INFRASTRUCTURE PLANNING
THE INFRASTRUCTURE PLANNING (EXAMINATIONS PROCEDURE) RULES 2010
THE THANET EXTENSION OFFSHORE WIND FARM ORDER

Comments on the ExA's commentary on the dDCO submitted on behalf of the Port of London Authority and Estuary Services Limited

| Document Ref. | PLA 22 / ESL 22 |
| Date | 28 May 2019 |

Figure 1.2
Thanet Extension Cable Exclusion Area.

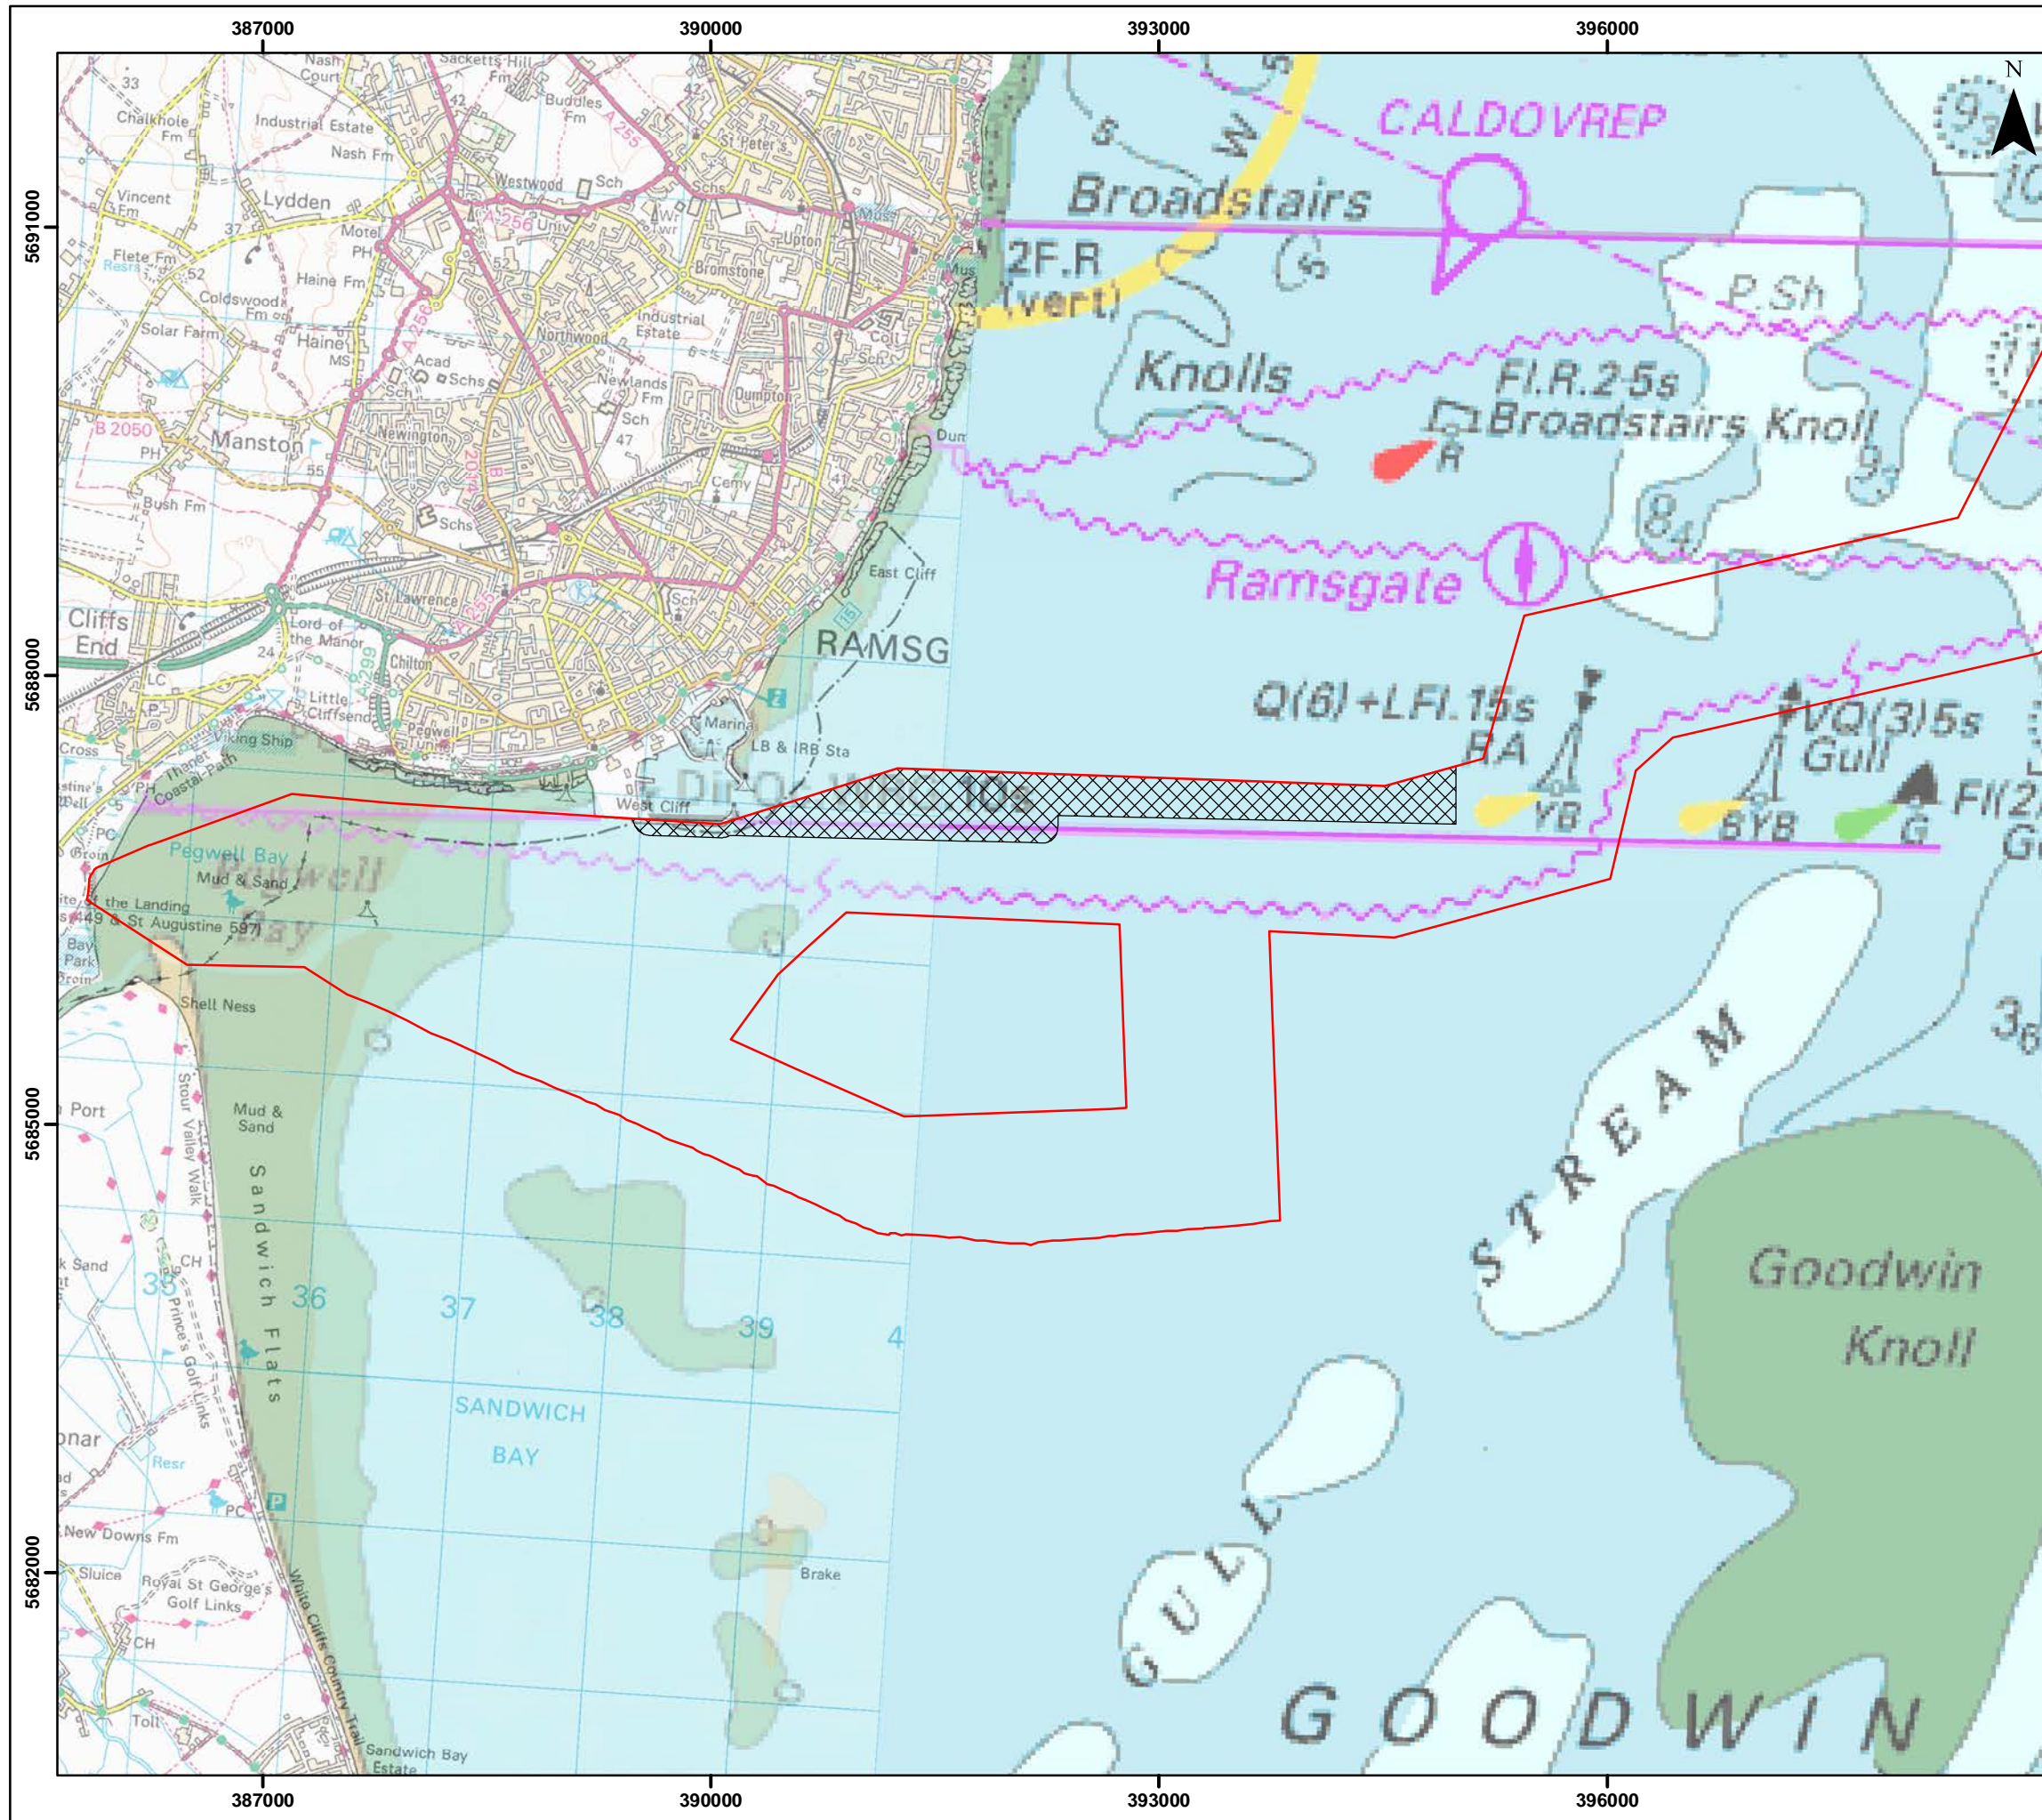
| Part of DCO (and ExA comment number) | PLA and/or ESL Comment |
|--------------------------------------|---|
| Sch 1 Parts 1 and 3 | <p>The PLA and ESL welcome the latest amendments made by the Applicant to the dDCO. However, concerns raised by the PLA and ESL at Deadline 5A remain (Document PLA 20/ESL 20).</p> <p>The amendment to paragraph 6 of Part 3 of Schedule 1 helpfully clarifies that no infrastructure that forms part of Work No. 1 (a) to (c), Work No. 2, in connection with Work No.s 1 to 3, Further Work (a), nor Ancillary Works (a), (c) and (d) may be installed within the structures exclusion zone (SEZ) and no part of any wind turbine generator, including its blades, may oversail into the SEZ. This, together with the deletion of the "subject to" wording in Part 1 of Schedule 1 resolves the PLA and ESL's concerns with that previous wording and the uncertainty as to which of Work</p> |

| | <p>Nos. 1 to 3 were being excluded and that the “temporary” nature of the exclusion.</p> <p><i>Cabling works within SEZ</i></p> <p>The laying and maintaining of cabling will still be permitted within the SEZ. The PLA and ESL recognise the need for cabling, to provide a connection for the proposed wind farm extension. However, it is still unclear as to where precisely these cables will be and the timing of cabling works. As a result, the Applicant would be permitted by the DCO to interfere with navigation within the SEZ for an unlimited period and over an unlimited area within the SEZ. This clearly does not achieve the certainty which the PLA and ESL are seeking when it comes to resolving their concerns in so far as they relate to the use of the SEZ by the Applicant and the impact of that use on navigational safety. The PLA and ESL's concerns would be resolved if the DCO and DCO works plans were amended to show reasonable corridors in which the works for the four offshore subsea export cables and fibre optic cables (Work No. 3) are to be authorised, instead of authorising those works anywhere within the SEZ.</p> <p><i>Construction, operation, maintenance and decommissioning</i></p> <p>The amendment to paragraph 6 of Part 3 of Schedule places a limitation on the “installation” of certain Works within the SEZ. It does not limit the use of the SEZ for the operation, maintenance or decommissioning of Works which are not within the SEZ. The Applicant will therefore have the power to use the SEZ in connection with the operation, maintenance and decommissioning of the rest of the wind farm. These activities, if undertaken within the SEZ, could be highly disruptive to navigation and pose a risk to navigational safety, as described in detail in the PLA and ESL's previous submissions and those of other IPs. The PLA and ESL would therefore request that the DCO be amended to exclude the use of the SEZ other than for cabling, provided that the cable locations and associated works are clearly identified and limited on the works plans.</p> |
